December 9, 2022

Re: Montgomery/ Wyoming Apartments
4615 Wyoming Blvd. NE
Traffic Circulation Layout
Engineer's Stamp 11-08-22 (F19-D013C)

Based upon the information provided in your submittal received 11-16-22, the above referenced plan cannot be approved for Building Permit until the following comments are addressed:

ENGINEER'S SEAL	MONTGOMERY/ WYOMING APARTMENTS	DRAWN BY RMG
		TRAFFIC CIRCULATION LAYOUT	DATE 12/20/2022
		TERRA WEST, LLC 5571 MIDWAY PARK PLACE NE ALBUQUERQUE, NM 87109 (505) 858-3100 www.tierrowestllc.com	2022030_TCL PLAN
			SHEET # TCL-1 JOB # 2022030

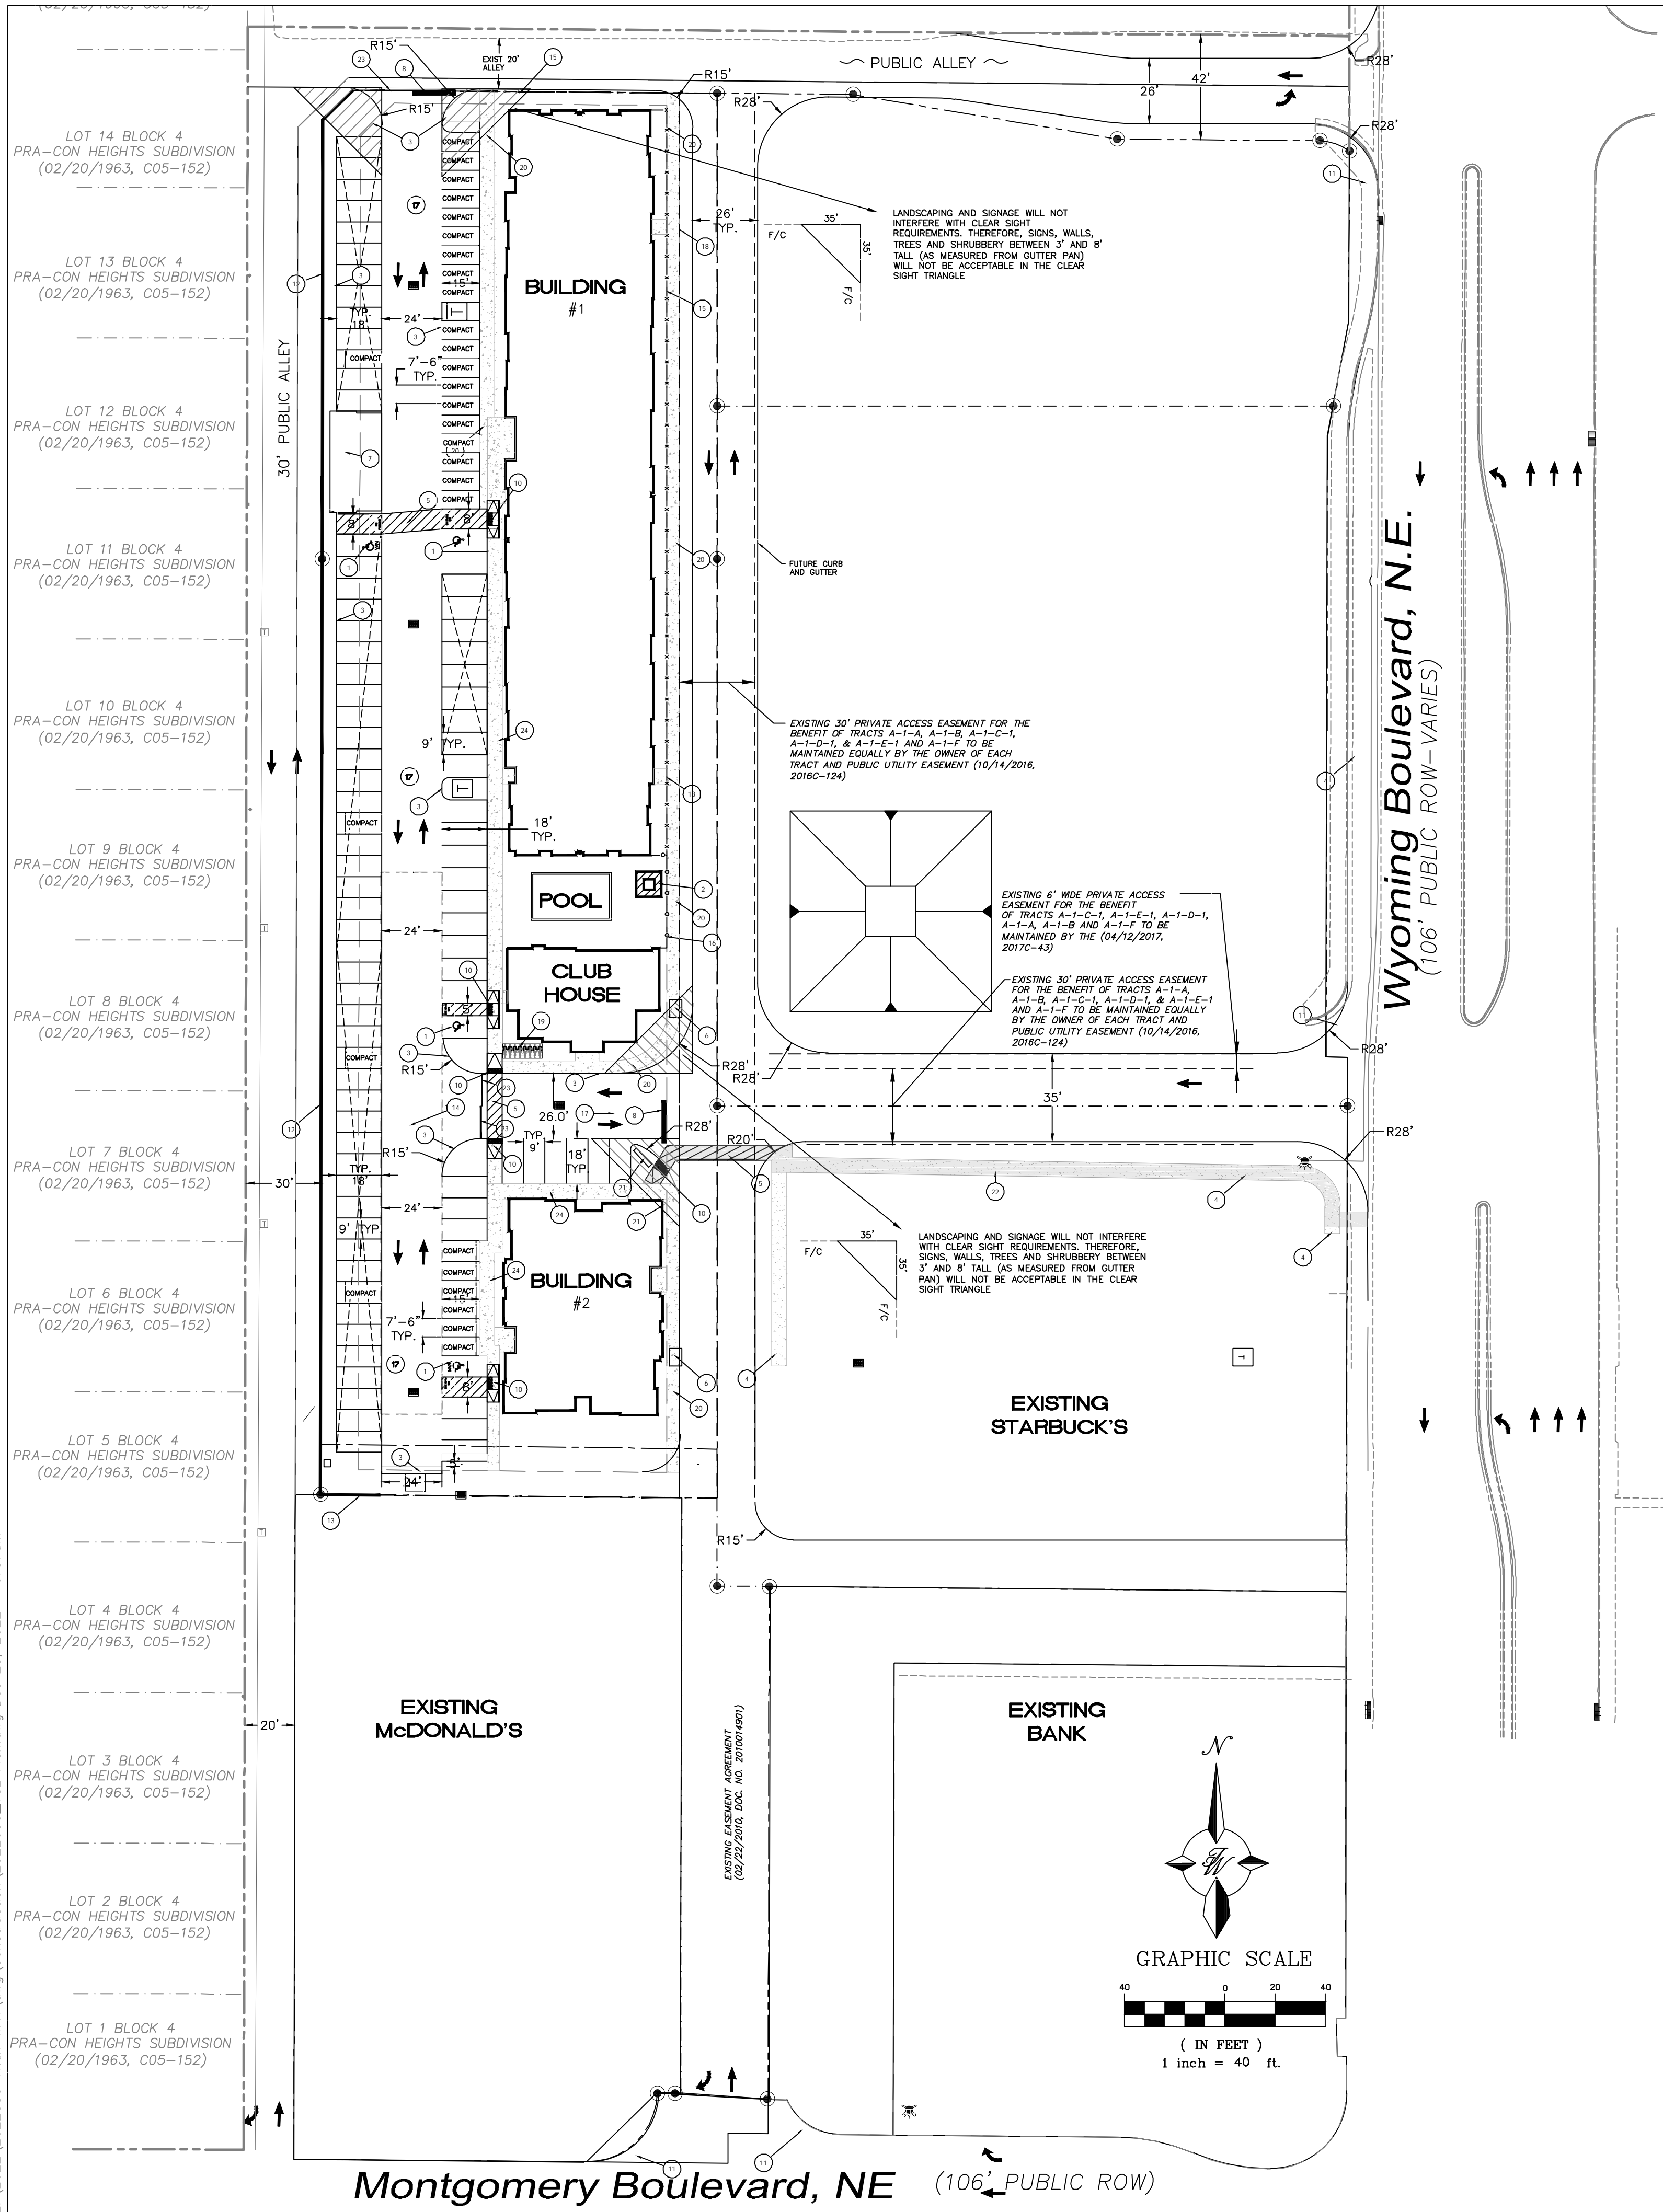
1. Identify all existing access easements and rights of way width dimensions.
2. Please provide shared access agreement, and approved plat.
3. Details sheet is missing.
4. Please list the width and length for all proposed parking spaces. Some dimensions are not shown.
5. The minimum parking stall dimensions are:

Type of parking	Min. Width	Min. Length	Min. Overhang
Standard	8.5'	18'	2'
Compact	7.5'	15'	1.5'
Motorcycle	4'	8'	N/A
ADA	8.5'	18'	2'

6. The ADA accessible spaces must include an access aisle. Van accessible aisles should be 8ft wide; all others should be 5ft wide.
7. The ADA accessible parking sign must have the required language per 66-7-352.4C NMSA 1978 **"Violators Are Subject to a Fine and/or Towing."** Please call out detail and location of signs.
8. ADA curb ramps must be updated to current standards and have truncated domes installed.
9. Key note 10: provide details for all the interior ADA ramps.
10. Due to proposing gates in the site, please provide vehicles turning template.
11. All bicycle racks shall be designed according to the following guidelines:

- a. The rack shall be a minimum 30 inches tall and 18 inches wide.
 - b. The bicycle frame shall be supported horizontally at two or more places. Comb/toaster racks are not allowed.

- c. The rack shall be designed to support the bicycle in an upright position. See the IDO for additional information.
 - d. The rack allows varying bicycle frame sizes and styles to be attached.

- e. The user is not required to lift the bicycle onto the bicycle rack.
 - f. Each bicycle parking space is accessible without moving another bicycle.

12. Bicycle racks shall be sturdy and anchored to a concrete pad.
 13. A 1-foot clear zone around the bicycle parking stall shall be provided.
 14. Bicycle parking spaces shall be at least 6 feet long and 2 feet wide.

15. A 5 ft. keyway is required for dead-end parking aisles.
 16. Per the IDO, a 6 ft. wide ADA accessible pedestrian pathway is required from the public sidewalk to the building entrances. Please clearly show this pathway and provide details.

17. Per DPM, a 6 ft. wide ADA accessible pedestrian pathway is required from the ADA parking stall access aisles to the building entrances. Please clearly show this pathway and provide details.

18. Curbing should be installed to delineate landscape, parking, and pedestrian ways and identify points of access. Please call out detail and location of barrier curb.

19. Refuse vehicle maneuvering shall be contained on-site. The refuse vehicle shall not back into the public right of way. provide a copy of refuse approval.
